CITY OF ALBUQUERQUE

**Re: Dave and Buster's
2100 Louisiana Blvd NE
Request Permanent C.O. - Accepted
Engineer's Stamp dated: 9-10-14 (J19D038)
Certification dated: 8-29-16**

**RE: Winrock Redevelopment Dave and Busters
Grading and Drainage Plan
Engineers Stamp Date 9/10/14 (J19D038)**

**RE: Winrock Redevelopment Dave and Busters
Grading and Drainage Plan
Engineers Stamp Date 8/14/14 (J19D038)**

GRADING & DRAINAGE
PLAN

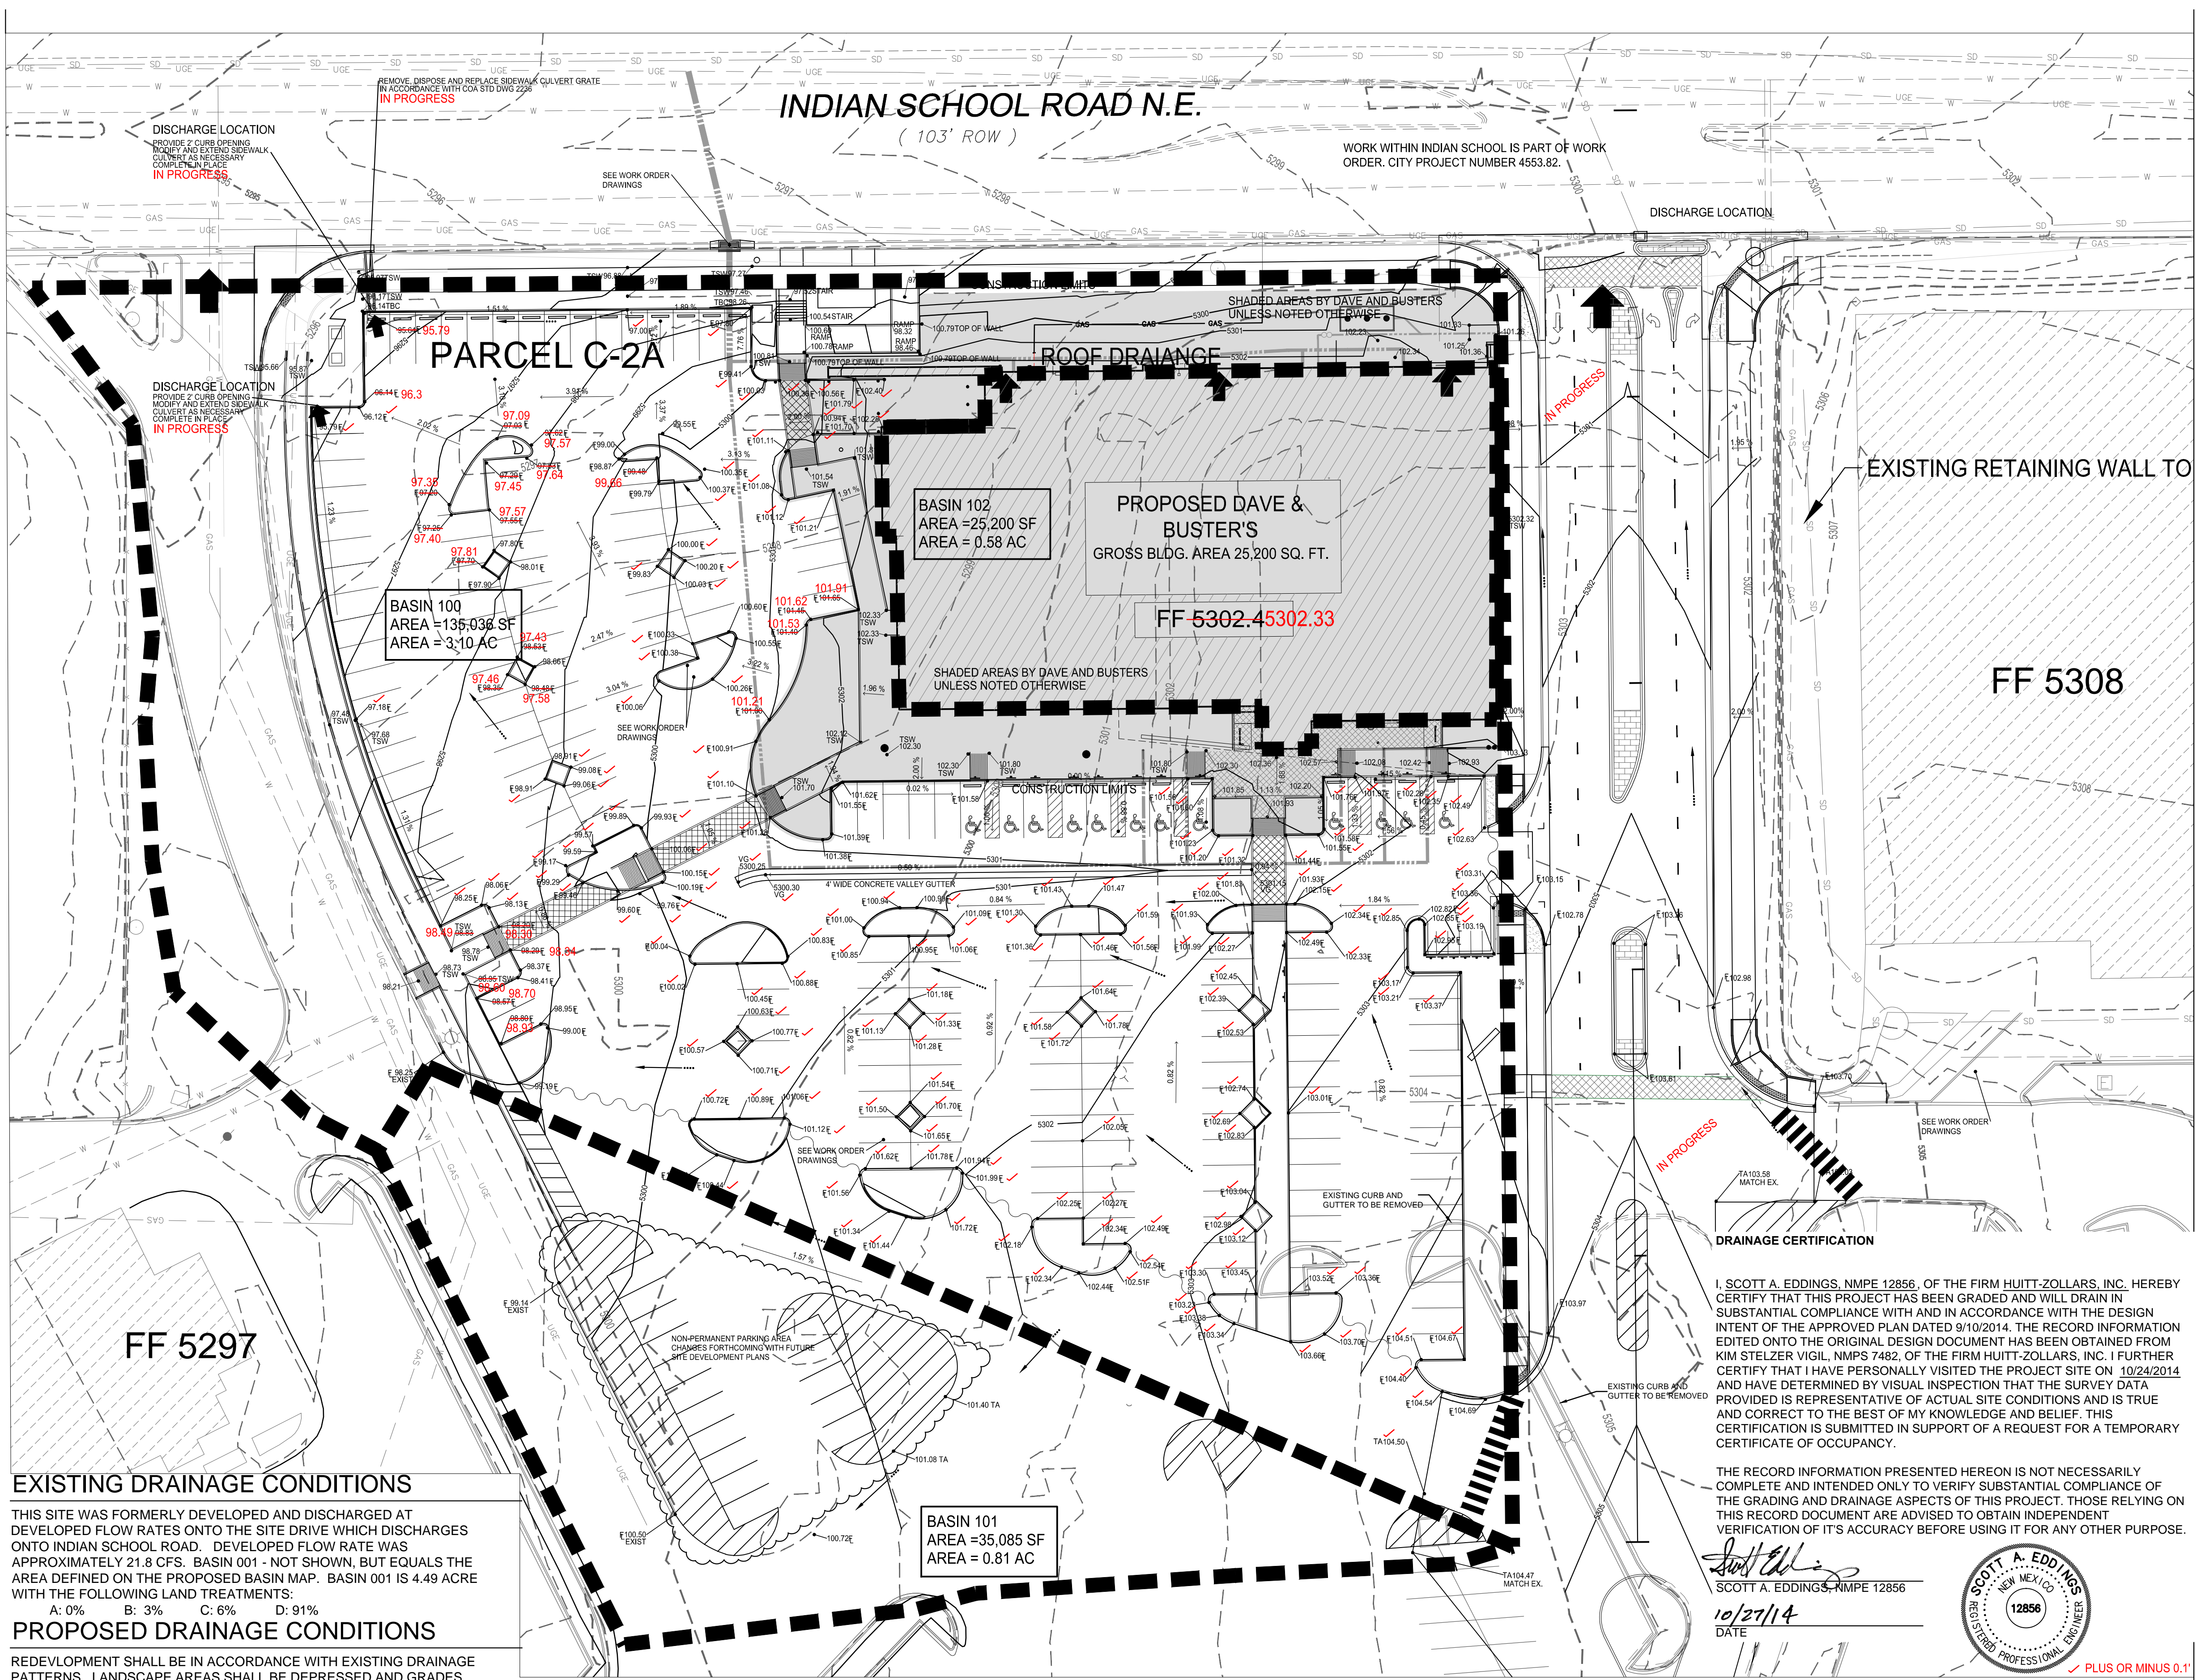
- 1) There appears to be a curb across the new access to the road along the west property boundary. This seems to be a drafting error that needs correction.
- 2) If the road along the west property boundary becomes public in the future, a valley gutter will be required at the west access

1. Regarding the parking islands on the southwest corner: It is not clear whether new parking islands are being built or if striping only. Contour lines extend ✓ though these islands, but a return curb would typically be required.

2. Detail all proposed islands along on south side of roadway/driveway showing spot Flowline Elevations.
3. Show a valley gutter and flowline elevations at the new curb returns at the new access. Label streets.

4. The Flowline Elevations on the parking islands are offset. It appears that the drafting layers are not correctly aligned.
5. I understand that the parking and traffic circulation were amended through an administrative amendment, but there seems to be a discontinuous pedestrian path though the parking island along at the south side of the new access.

6. If the Site Plan is being amended, do the drainage basins delineated on Site Plan SDP-6 (stamp date 10-3-13) still apply to this new condition?
7. A new ESC Plan will be needed with this amendment to the G&D plan.

1. Regarding the parking islands on the southwest corner: It is not clear whether new parking islands are being built or if striping only. Contour lines extend though these islands, but a return curb would typically be required. - *Noted for future work, SE 9.12.14*

2. Detail all proposed islands along on south side of roadway/driveway showing spot Flowline Elevations. ✓
3. Show a valley gutter and flowline elevations at the new curb returns at the new access. Label streets. - *Project will require reconfigure area in the future, SE 9.12.14*

4. The Flowline Elevations on the parking islands are offset. It appears that the drafting layers are not correctly aligned. ✓
5. I understand that the parking and traffic circulation were amended through an administrative amendment, but there seems to be a discontinuous pedestrian path though the parking island along at the south side of the new access.

6. If the Site Plan is being amended, do the drainage basins delineated on Site Plan SDP-6 (stamp date 10-3-13) still apply to this new condition? *Additional information included, SE 9/12/14*

7. A new ESC Plan will be needed with this amendment to the G&D plan. *- Construction is nearly complete, SE 9/12/14*
